6 May 2020

**FINAL RESPONSE TO SUBMISSIONS
MODIFICATION TO EASTLAKES SHOPPING CENTRE – MP 09_0146 MOD 4
GARDENERS ROAD & EVANS AVENUE, EASTLAKES**

Figure 44 | Proposed lengthening of right turn lane of Gardeners Road (shown red) and location of bus stops (shown yellow) (Base image source: Proponent's SRTS)

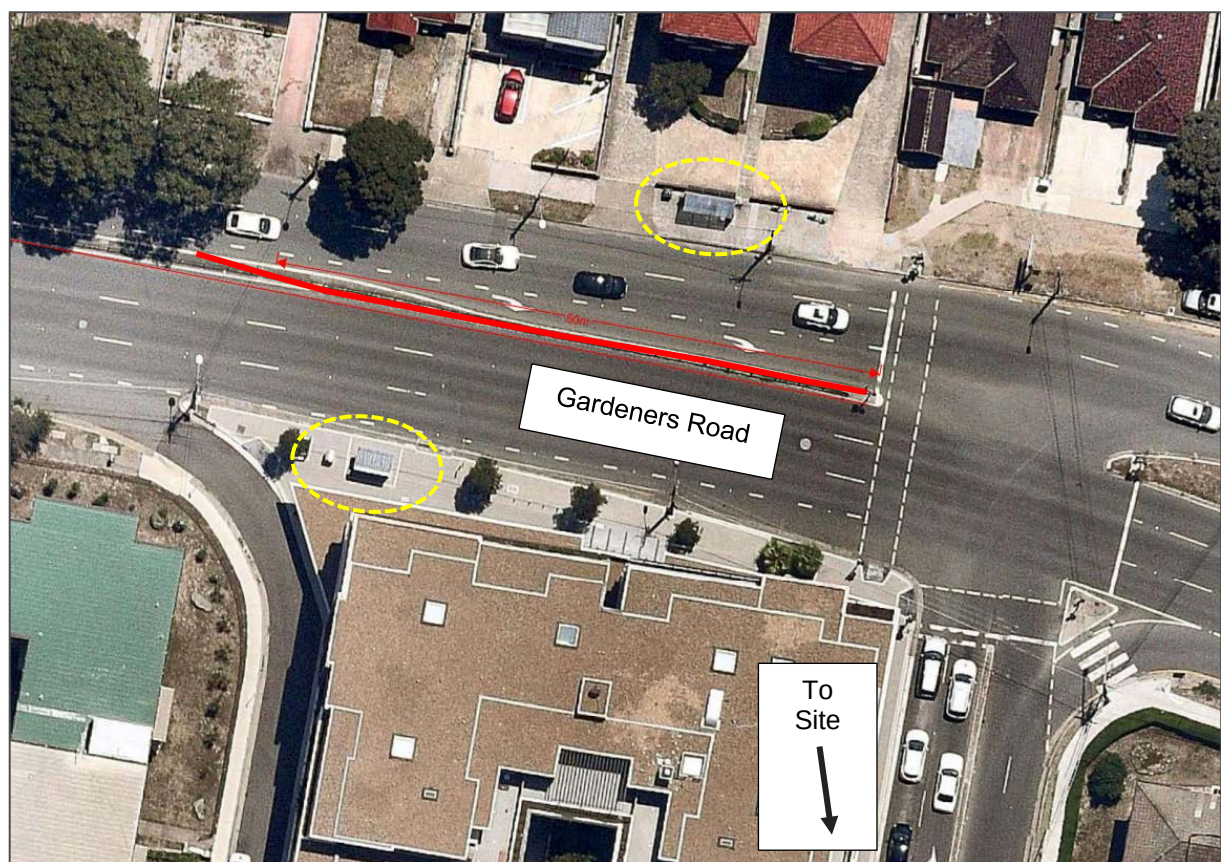
TfNSW has reviewed the submitted information and notes that the proponent proposes to amend the Gardeners Road / Racecourse Place intersection by extending the existing right turn bay on Gardeners Road into Racecourse Place taper as a means of alleviating the at capacity traffic levels on Gardeners Road. At this stage, TfNSW raises no objection to the concept proposal, however requires further review and approval under Section 87 of the *Roads Act 1993* and concurrence under Section 138 of the *Roads Act 1993*.

- Prior to the issue of any Construction Certificate the proponent will need to obtain Section 87 of the *Roads Act 1993* approval and concurrence under Section 138 of the *Roads Act 1993* for the proposed works on the Gardeners Road impacting the Gardeners Road / Racecourse Place intersection. The proponent is to submit an updated Traffic Control Signal Plan (TCS) for the intersection works on Gardeners Road / Racecourse Place to be reviewed by TfNSW, under Section 87 of the *Roads Act 1993*, for 'in principle' approval for the works.
